District: Cherwell

Application No: 21/01245/DISC

Proposal: Discharge of condition 41 (right of way alternative route) of 14/01932/OUT

Location: OS Parcel 7400 Adjoining and South Of, Salt Way, Bodicote

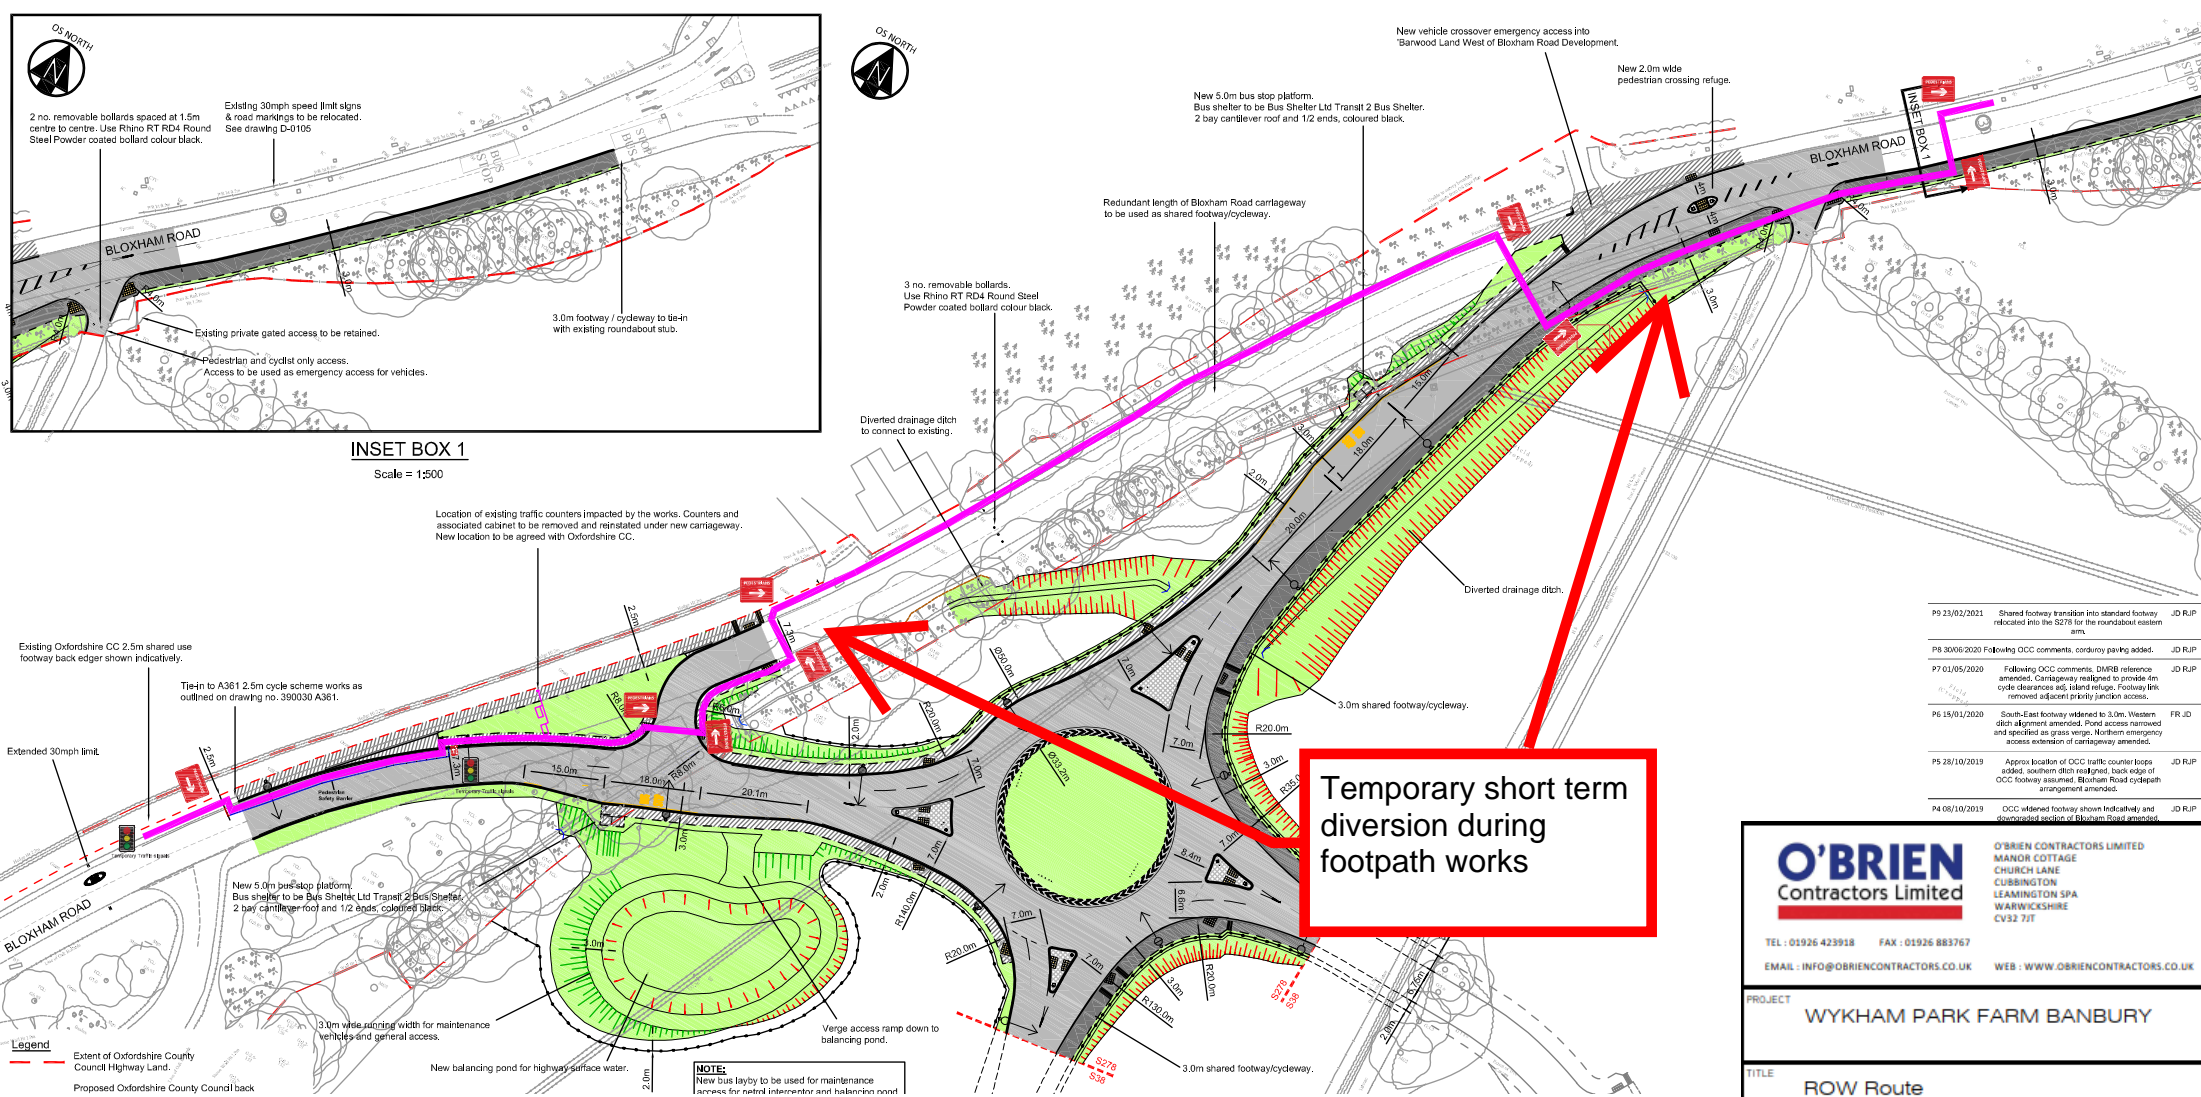
The details of the proposed diversion route are insufficient. The applicant must satisfactorily provide details of crossing facilities (of the A361 and access/spine roads), cross-sections, surfaces, furniture, lighting etc. The proposed alternative route cannot be deemed acceptable until these aspects have been clarified and found to be acceptable.
